CITY OF ALBUQUERQUE

September 28, 2007

**Re: Cibola Energy Corporation Grading and Drainage Plan
Engineer's Stamp dated 9-28-07 (J13/D090)**

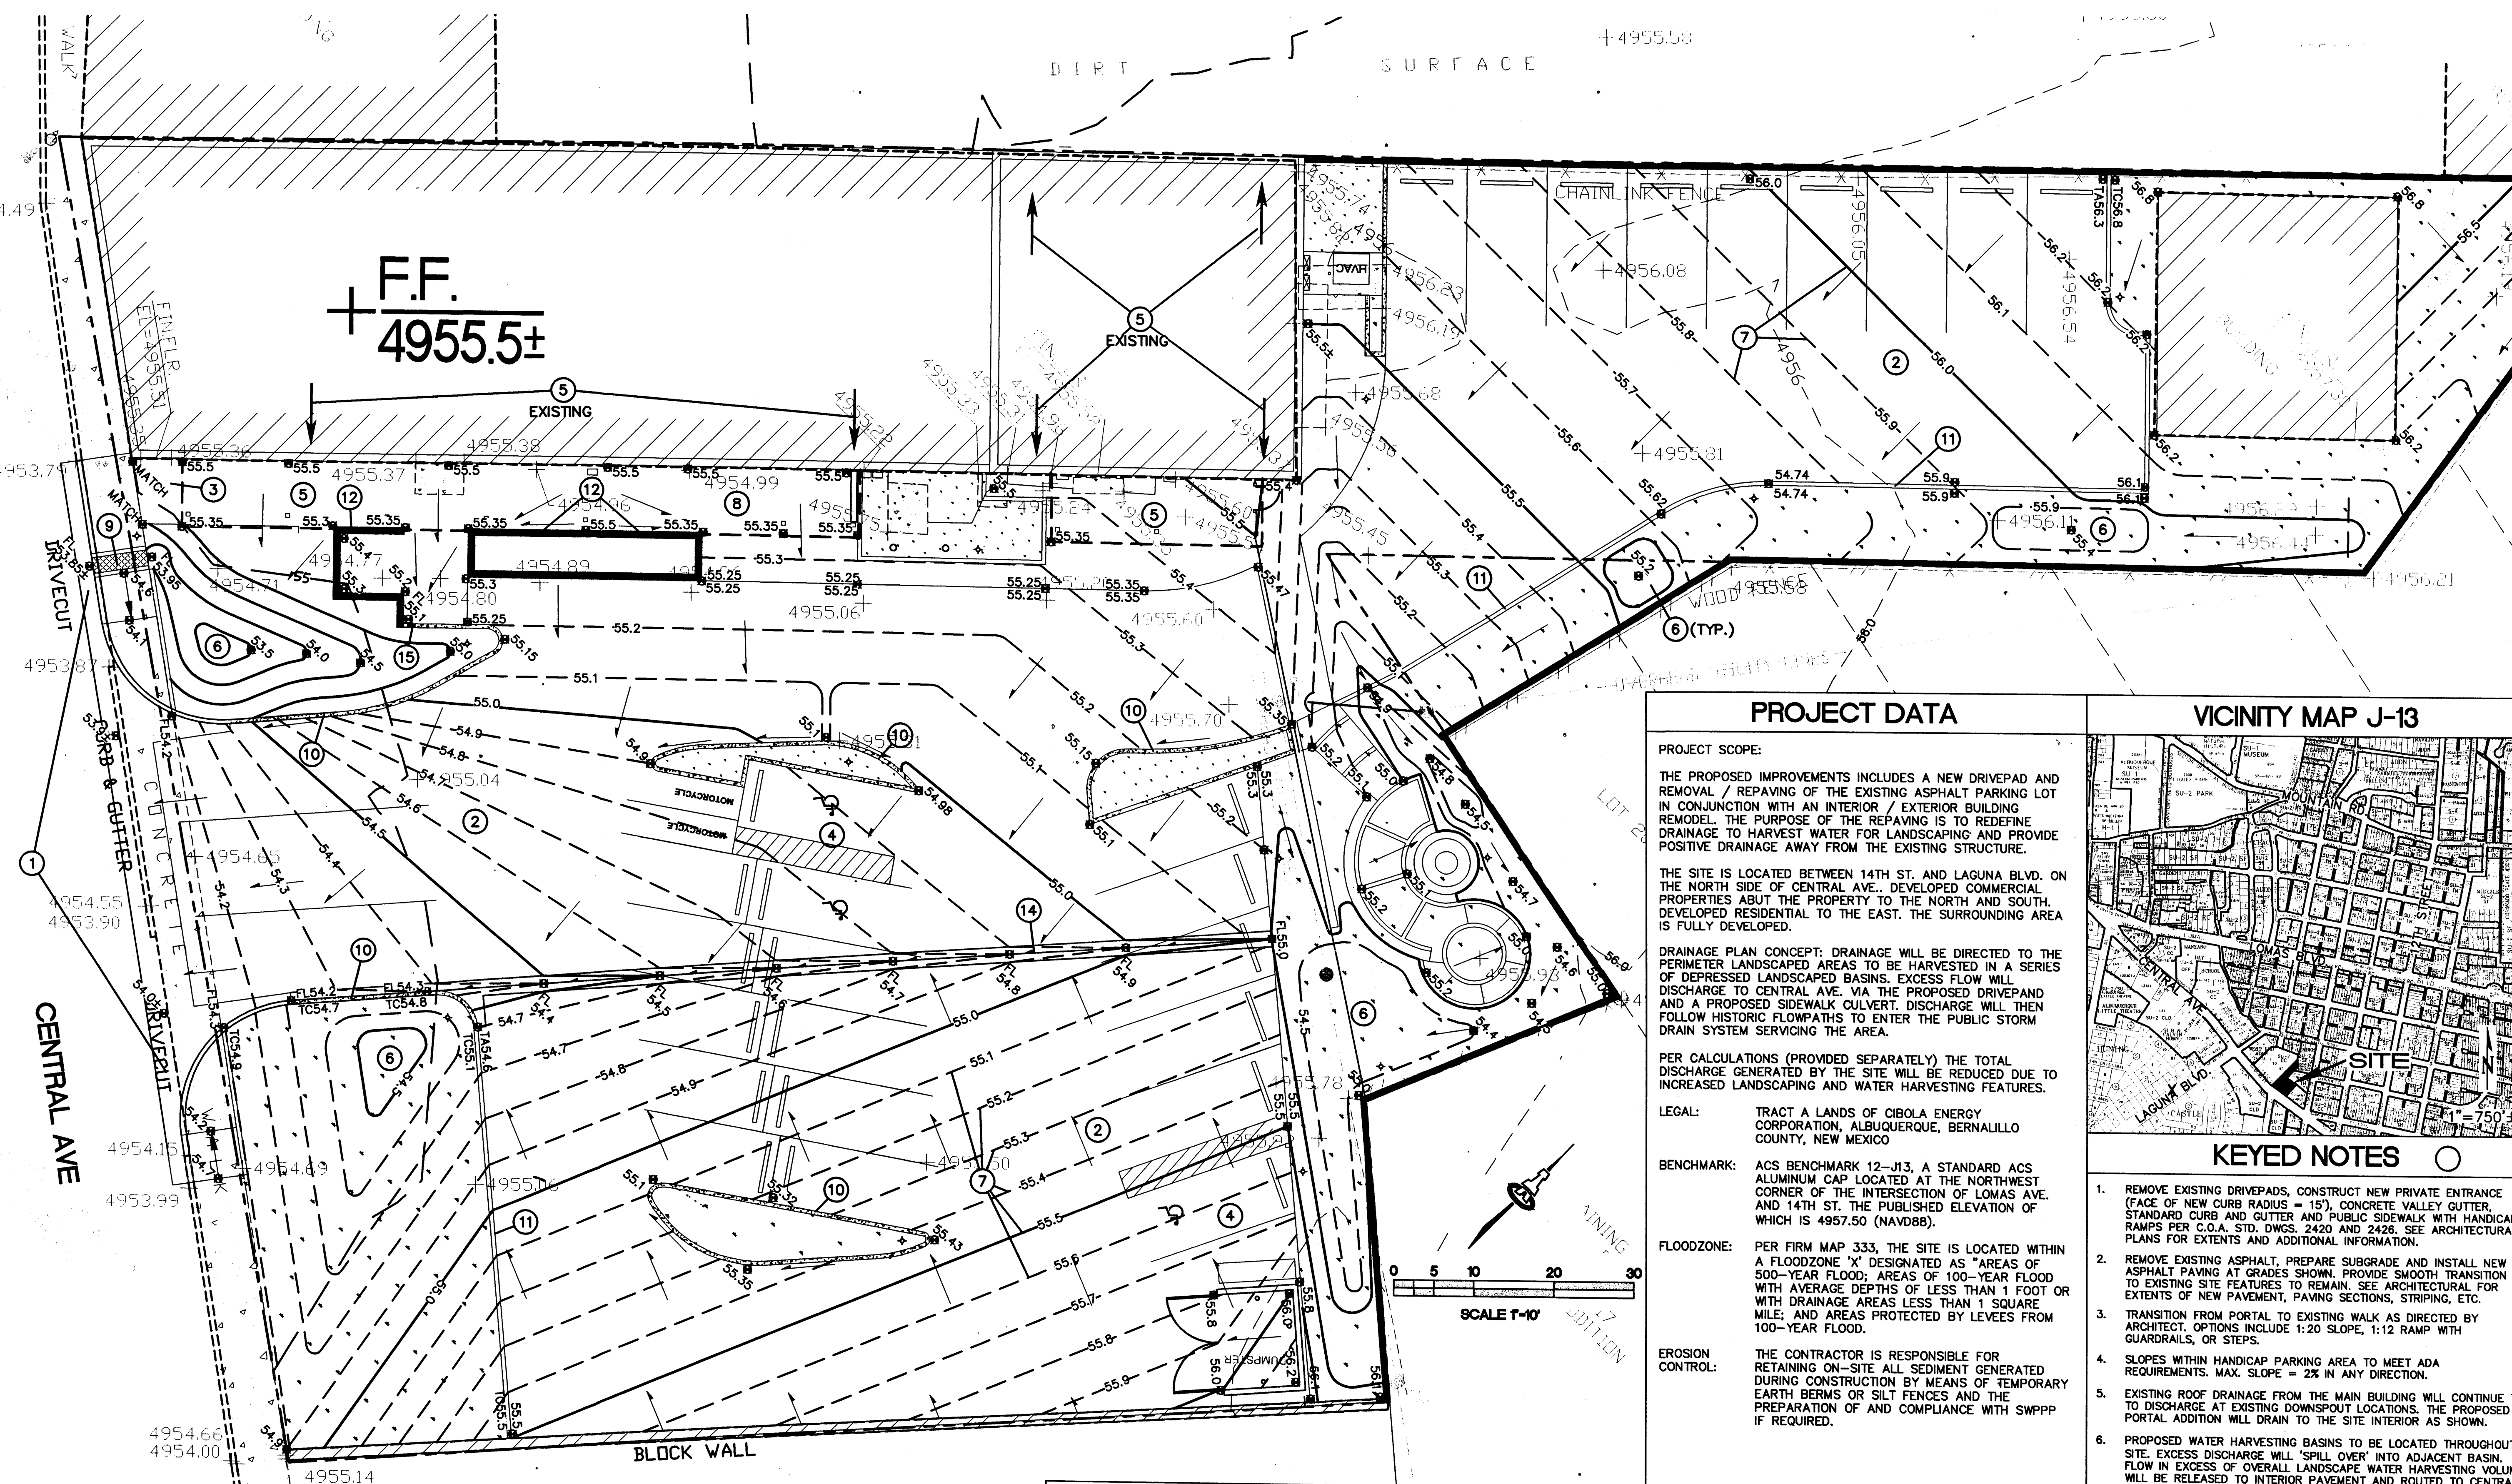
- The legal description on the DTIS should be updated to reflect work on lots 19 and 20 as well as the lots listed.
- A cross-lot(s) drainage easement is required. There appears to be 6 lots involved.
- Roofs should drain to the site interior. Provide direction of roof flows.
- Provide the upstream invert for the east sidewalk culvert.
- Provide a means to prevent runoff from crossing the property line to the north in the landscaped area near the north arrow. In addition, provide proposed elevation data near the property line.
- Provide details for curbs stated in notes 10 and 11.

- ✓ The properties are undergoing a replat to a single property. A copy of the proposed plat is included with this letter for your files.
- No cross-lot drainage easements required (see above comment).
- ✓ Roof drain directions indicated on plan. Existing roof drainage to continue as historical. New portal roofs to shed to site interior.
- Site grading revised based on new architectural and landscape information. Original drainage concept maintained.
- ✓ New CMU wall along north and east boundary will prevent run-off from crossing the property line to the north in the landscaped area. Additional proposed elevation data provided.
- Details provided for median curb and gutter and ribbon curb.
